RE: Modification request for Star City Casino and Switching Station – Modification 14 (MP 08_0098 MOD 14)

Katrina Stankowski
Acting Manager, Conservation
Heritage Division
Office of Environment & Heritage
As Delegate of the NSW Heritage Council

1 PROPOSED FLOOR PLAN_ LEVEL 00-PART 1A
1: 250

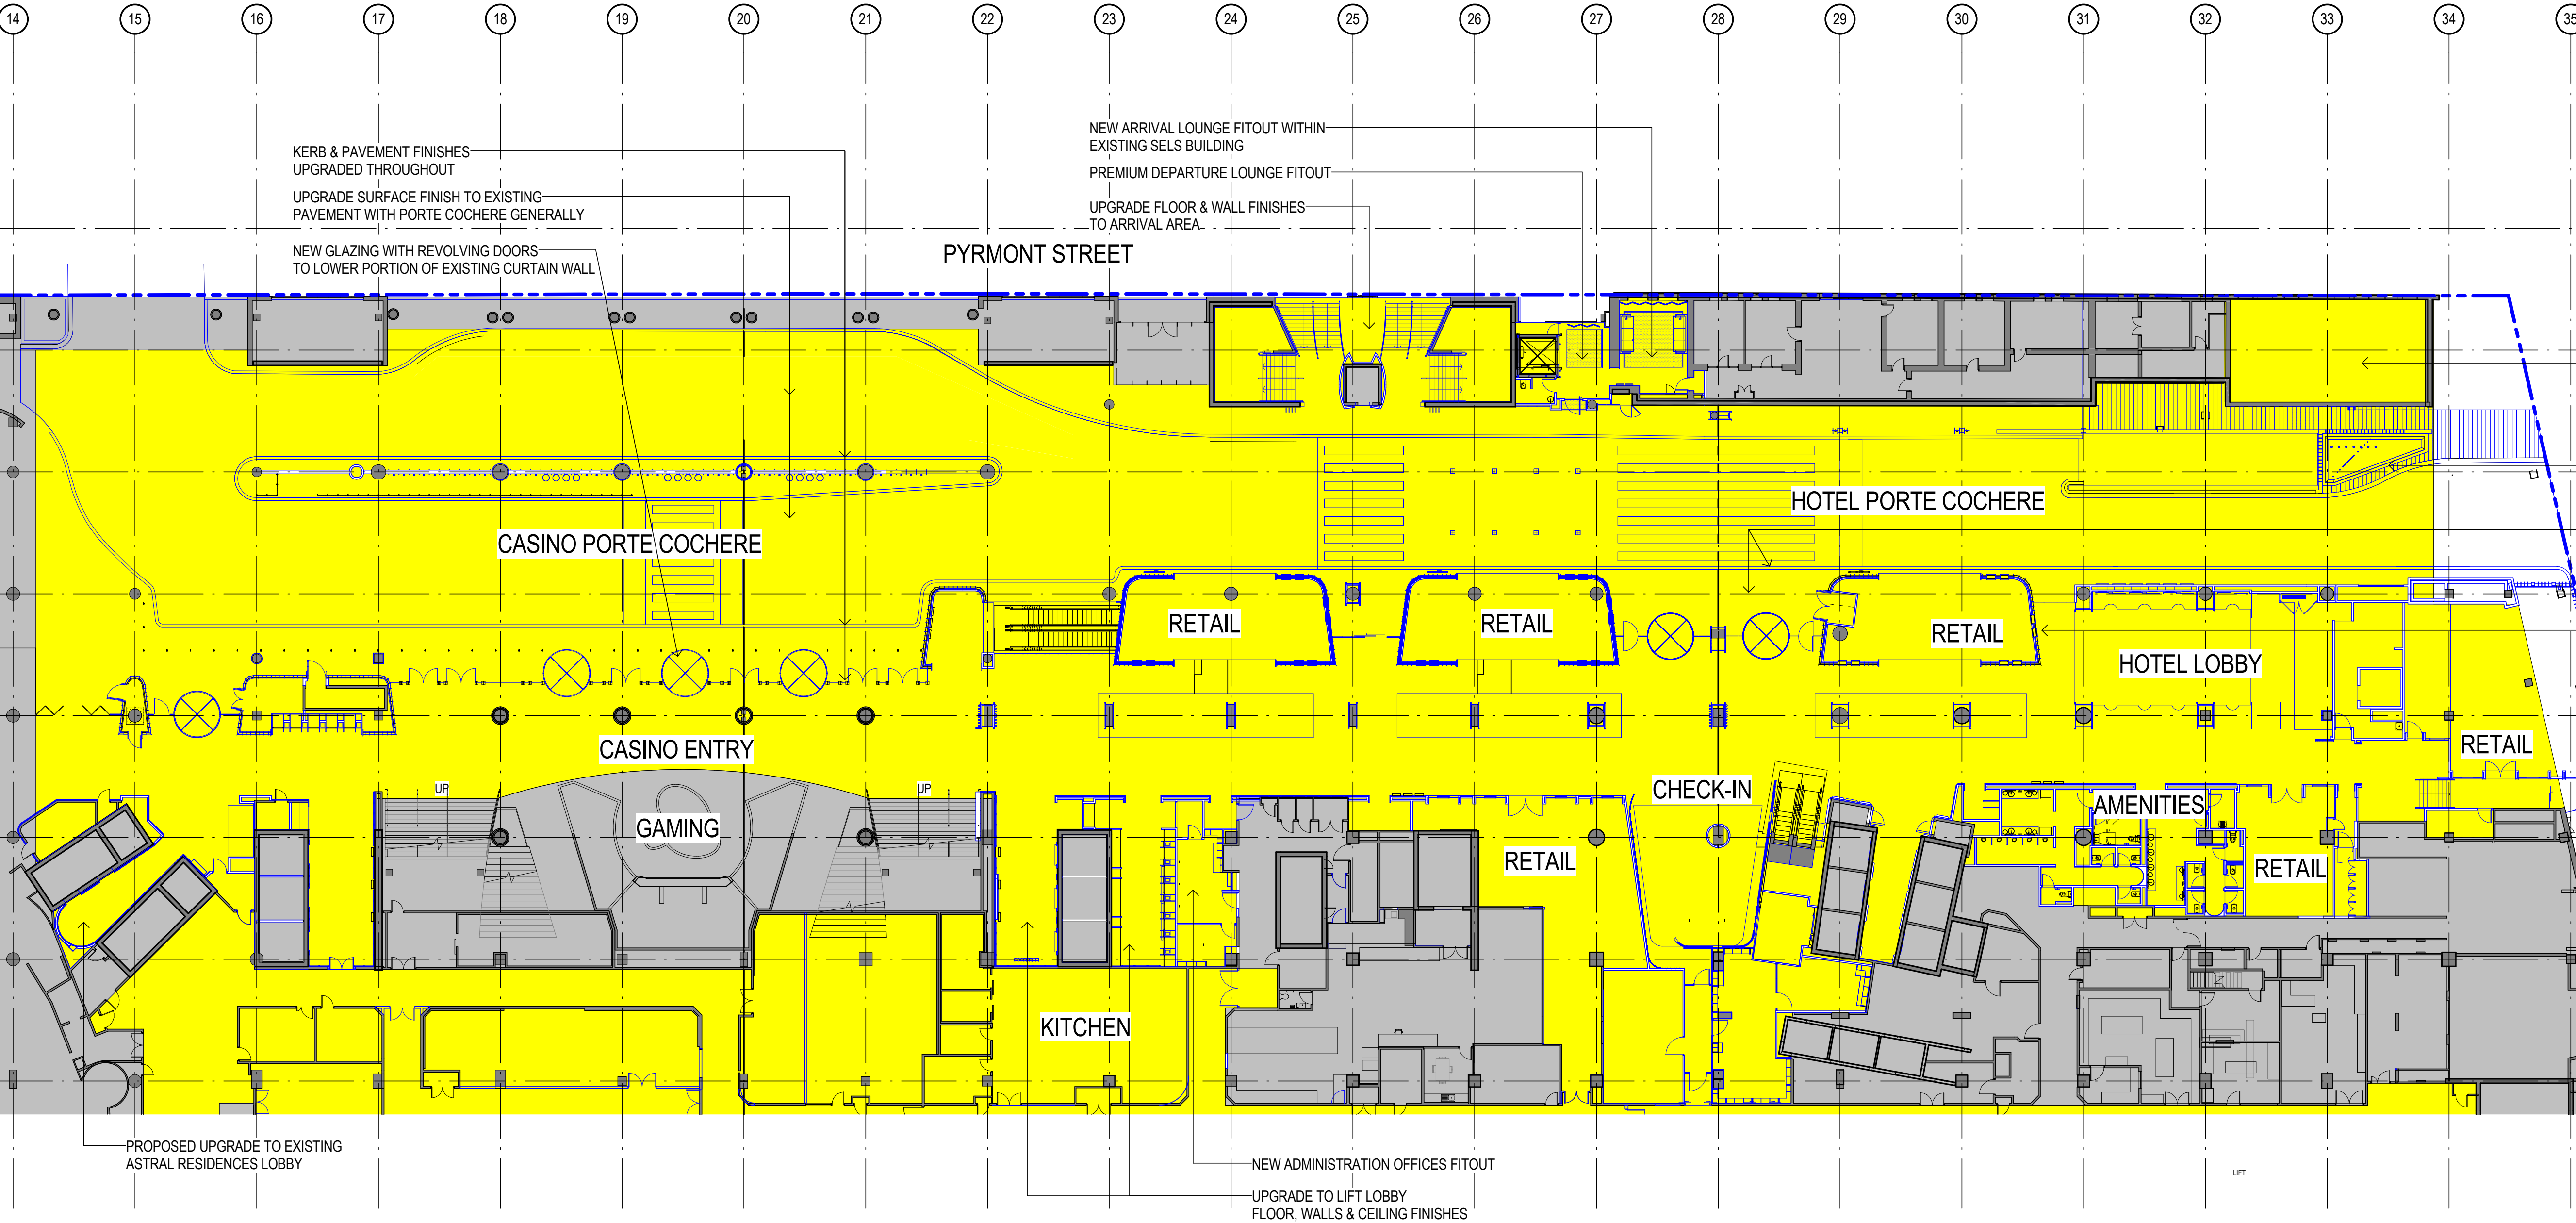
The design of the proposed water feature, including its form, proportions, material and colour should sit well and engage harmoniously with the architectural style of the SELS building. More information and design detail should be submitted by the applicant to enable proper assessment.

2 FLOOR PLAN-NORTHERN PORTE COCHERE CANOPY
1 : 250

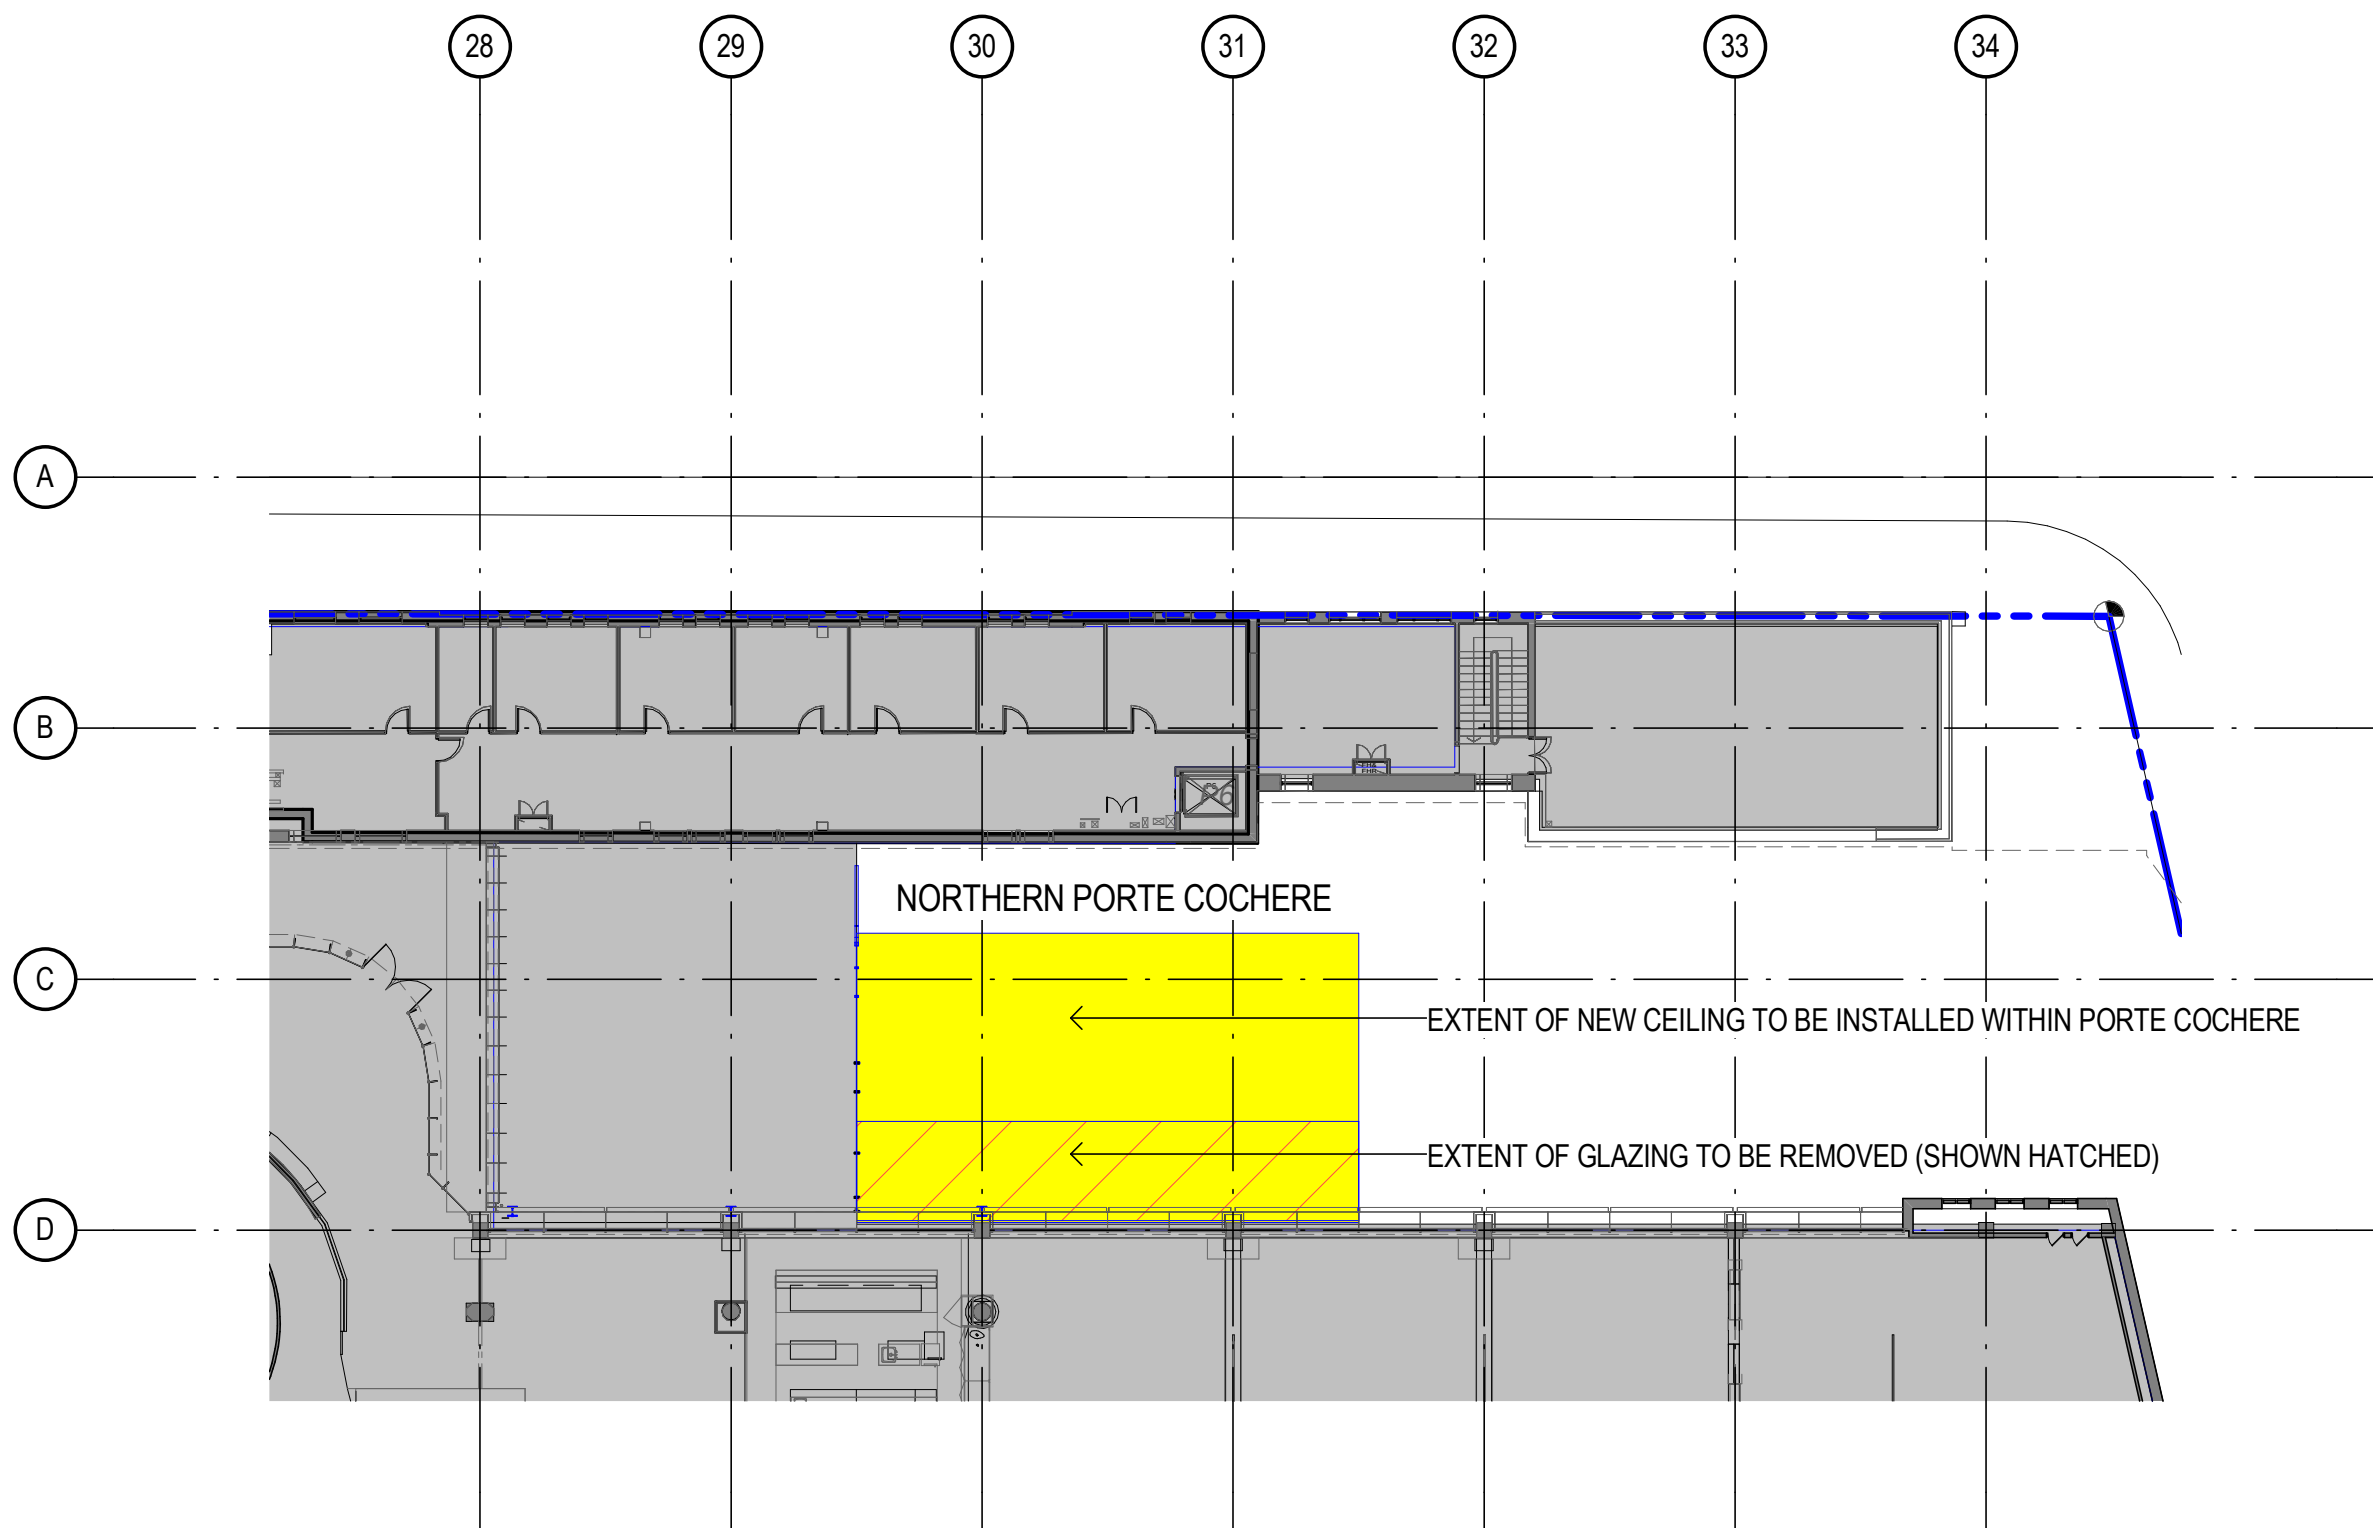
The design of the proposed Porte Cochere Canopy should, including its form, proportions, material and colour, sit well and engage with the architectural style of the SELS building. More information and detail design should be submitted by the applicant to enable proper assessment.
